Technical Note

Date: 15 April 2025
Project Reference 43-67 High Street, Yiewsley

Air Quality Technical Note

- 1.1 This air quality technical note has been prepared in response to post-stage 1 comments made by the GLA in relation to the Air Quality Assessment (AQA) for 43-67 High Street, Yiewsley (ref. JAR03313, dated 01/06/2023). The GLA made a total of five post-stage 1 comments in relation to RPS' AQA.
- 1.2 RPS has addressed these comments below.
- 1.3 **GLA Comment:** *"It should be noted given the length of time since the original submission, some information in the AQA is now out of date. Baseline information in the original assessment only considers monitoring data to 2019. It would be preferable to consider updated monitoring data, however it is acknowledged this is not likely to affect the overall outcomes of the assessment."*

**Figure 1: Modelled Road Links and Receptors**

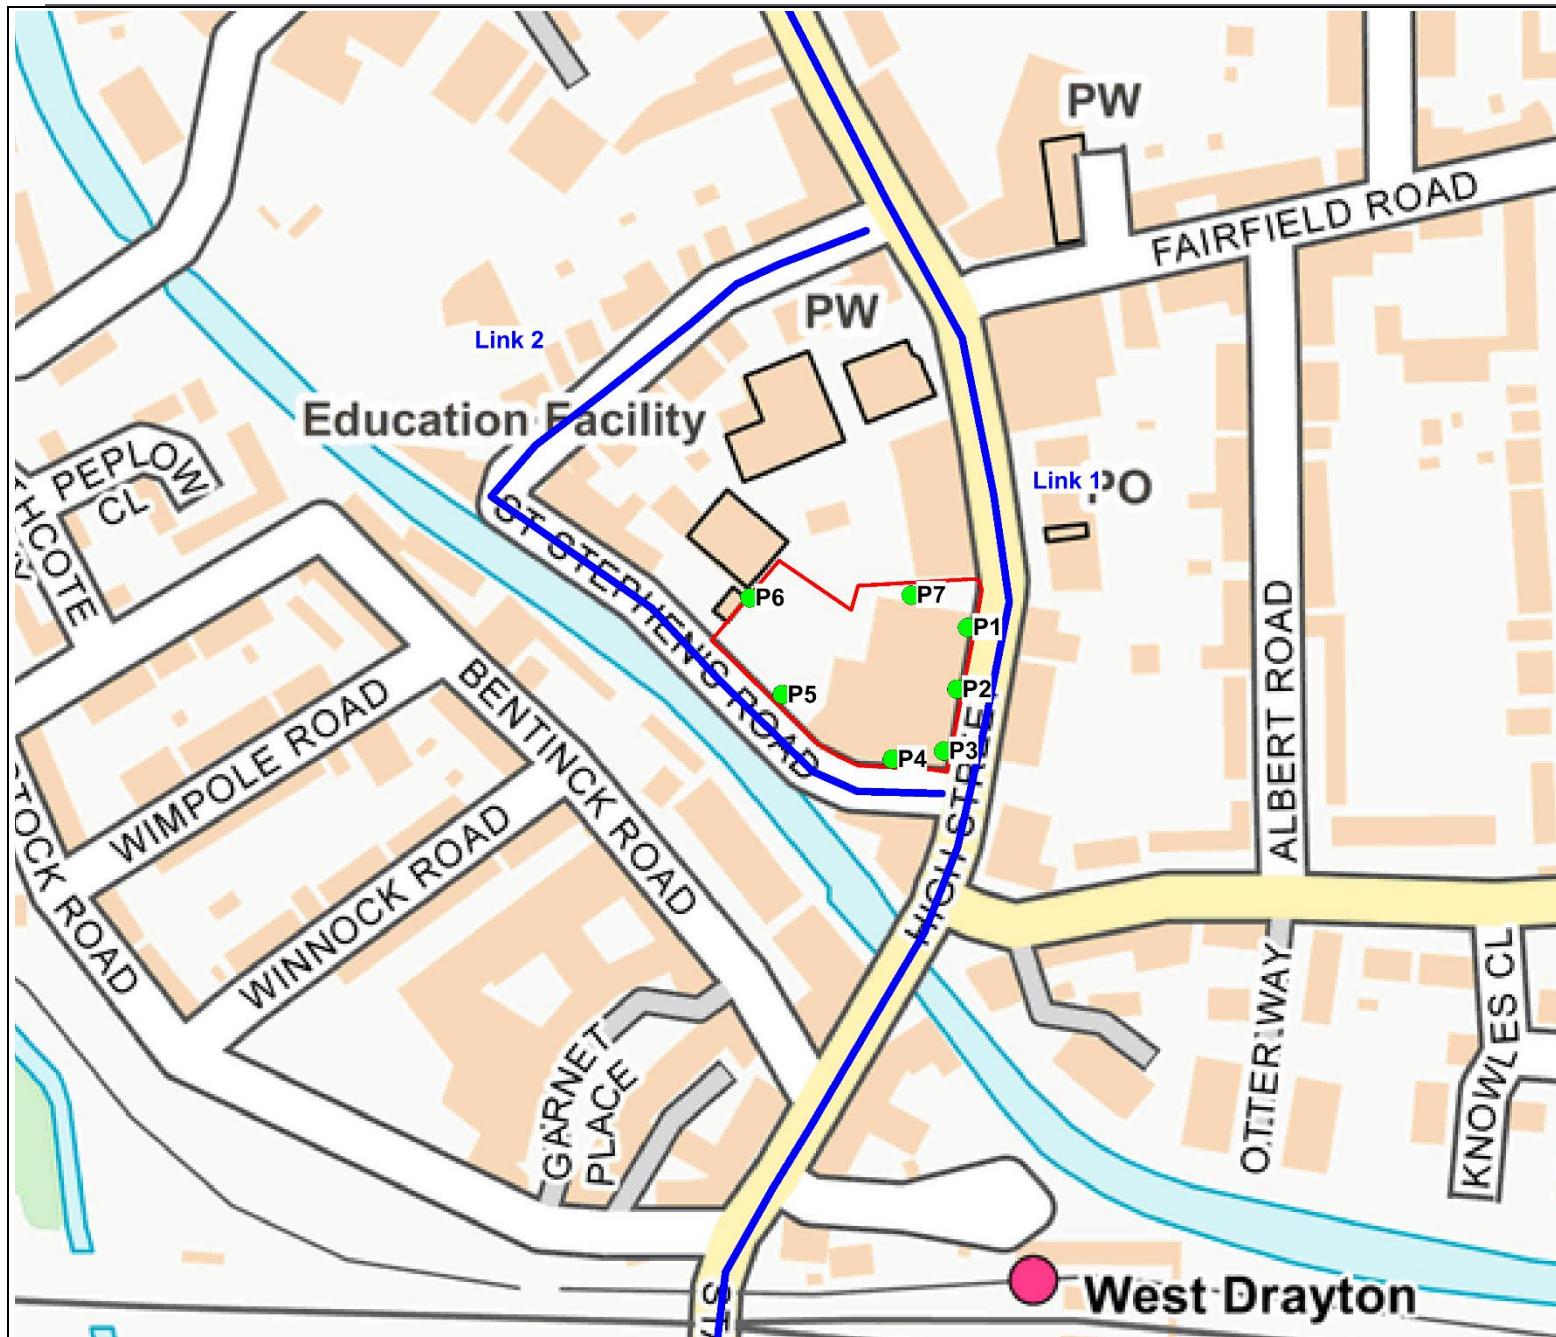
- 1.6 **GLA Comment:** *"The inclusion of a figure demonstrating the location of local monitoring sites in relation to the proposed development / modelled roads would be beneficial."*

Figure 1 below has been prepared showing the location of the background monitors in relation to the proposed development site.
